DRB CASE ACTION LOG (SITE PLAN B.P.)

DRB Application No.: 05DRB-00623 (SBP)

Project # 1003360

Project Name: JOHN ADAMS MULTIPUR CTR

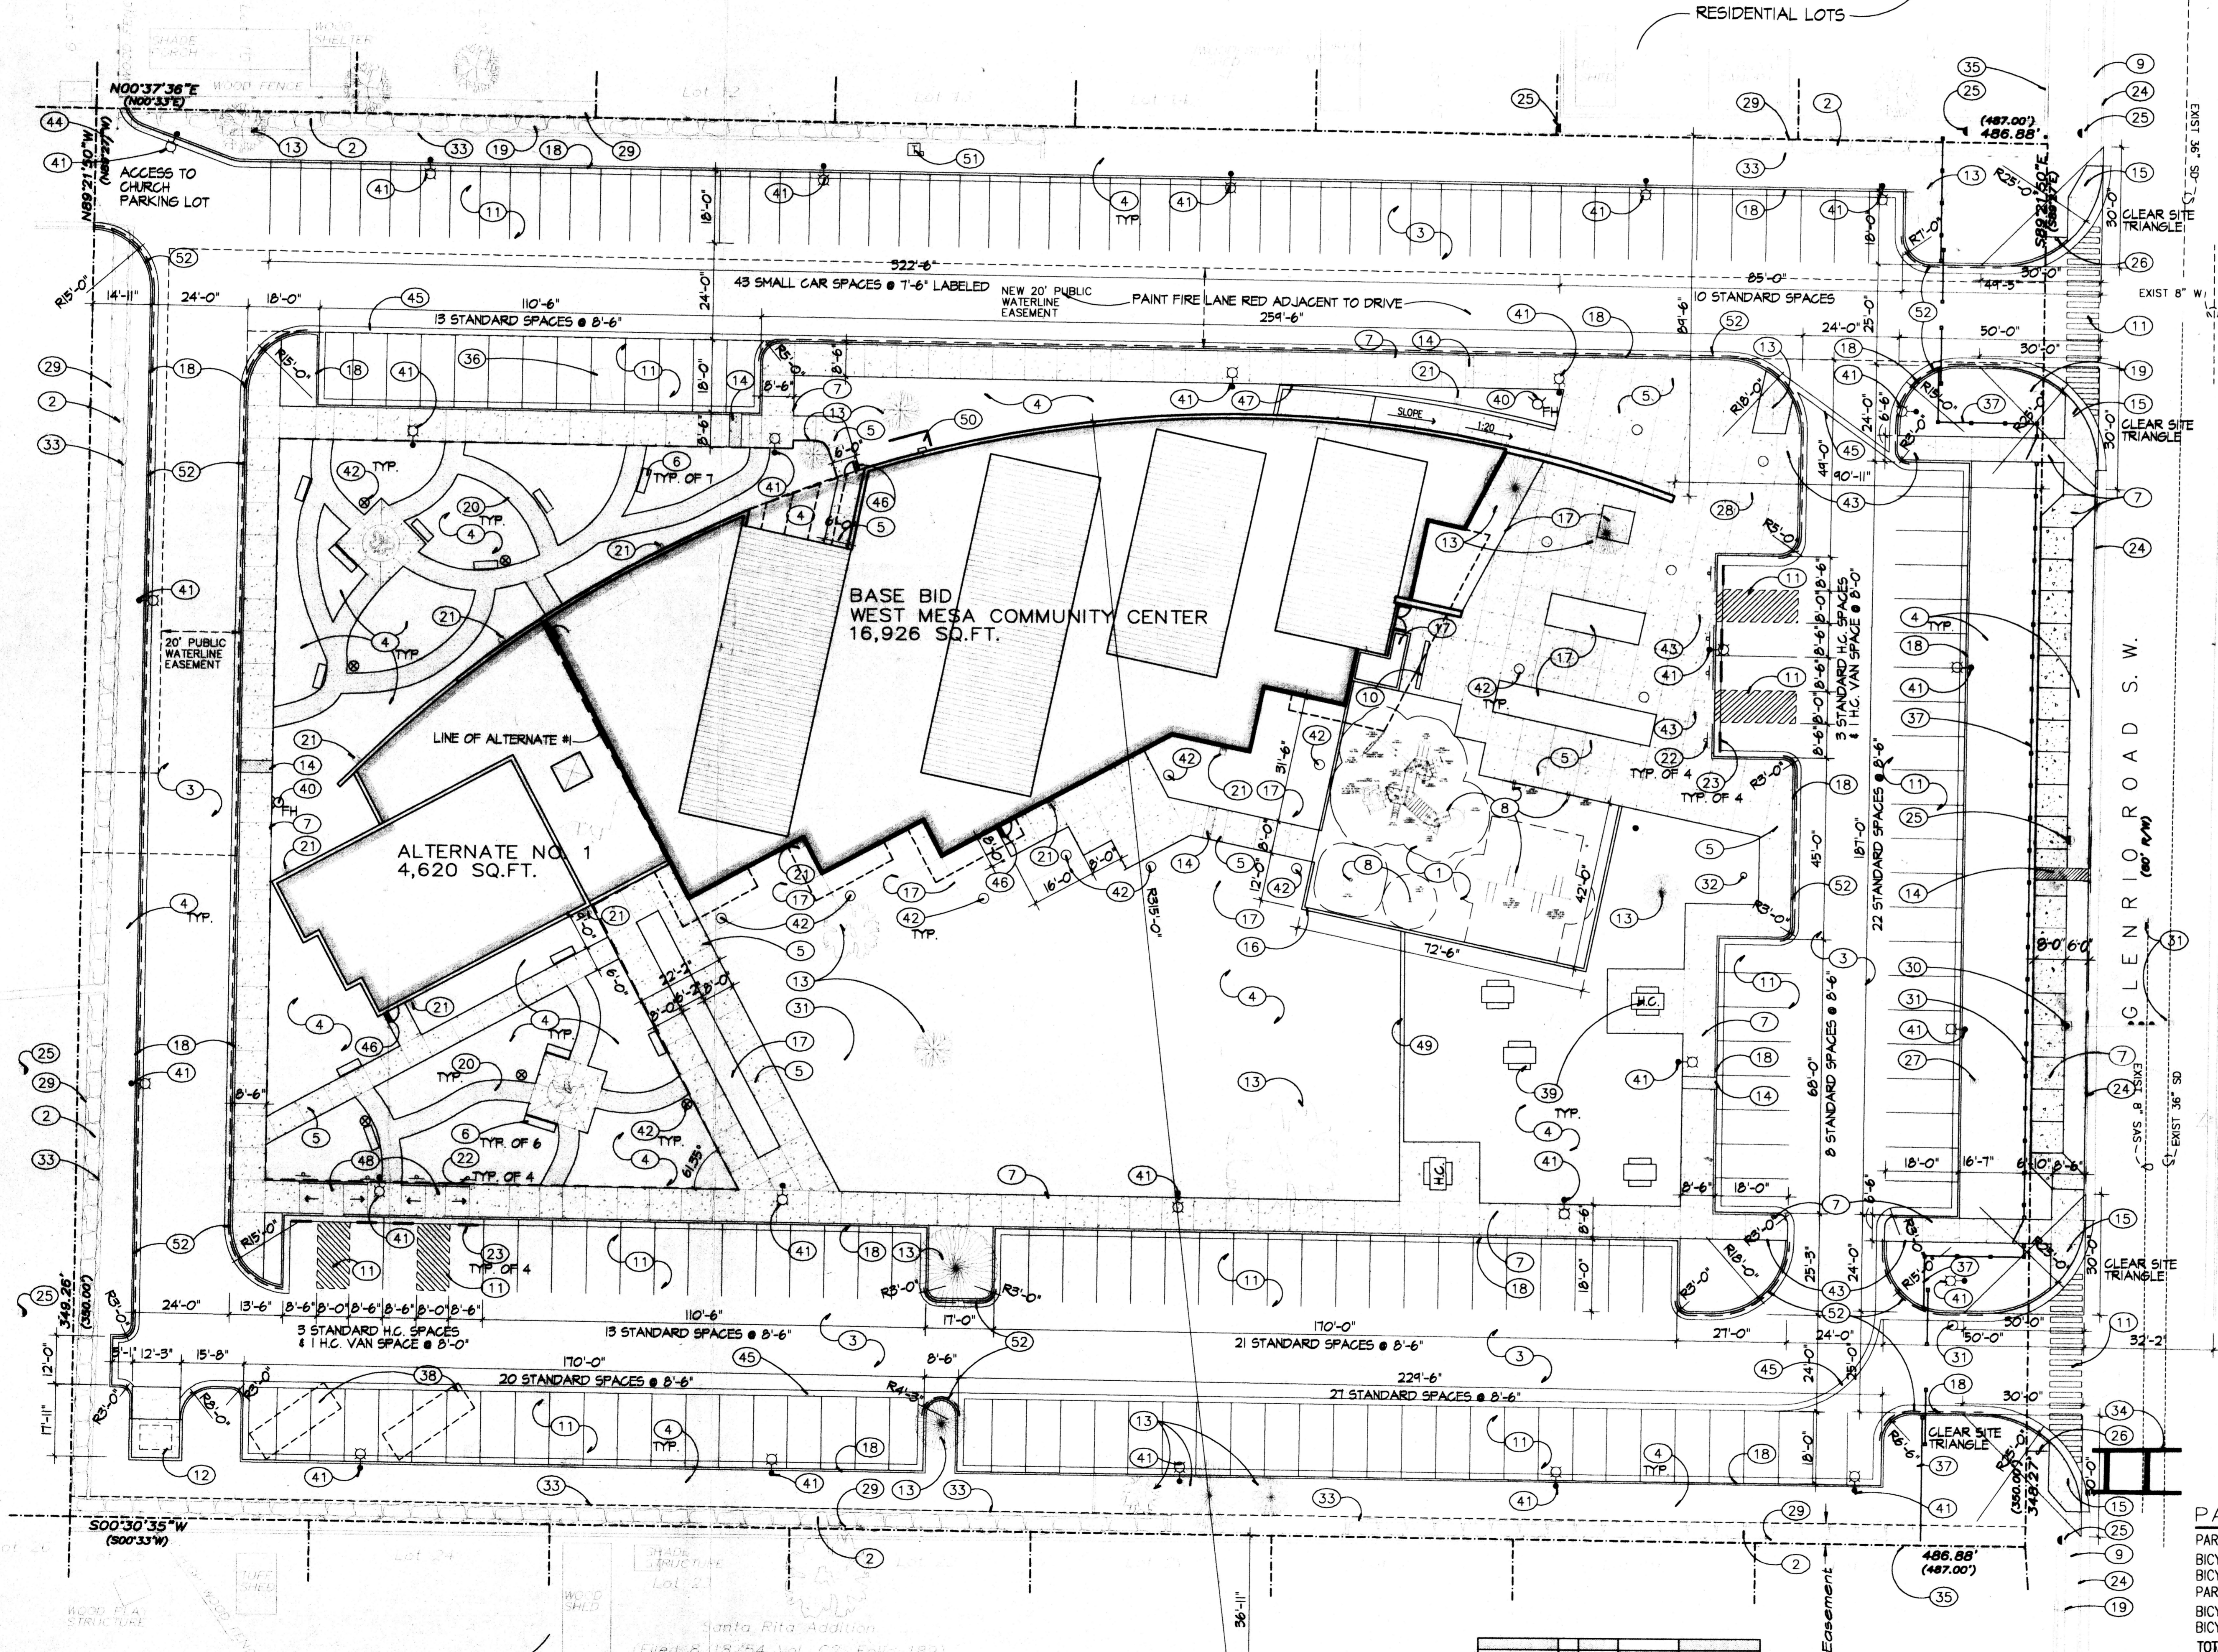
- TRANSPORTATION: * CITY STANDARD DWG N^os for CURB RETURNS
- * SW @ PROPERTY LINE
- * PARKING CALCULATIONS *OK*
- _____
- _____
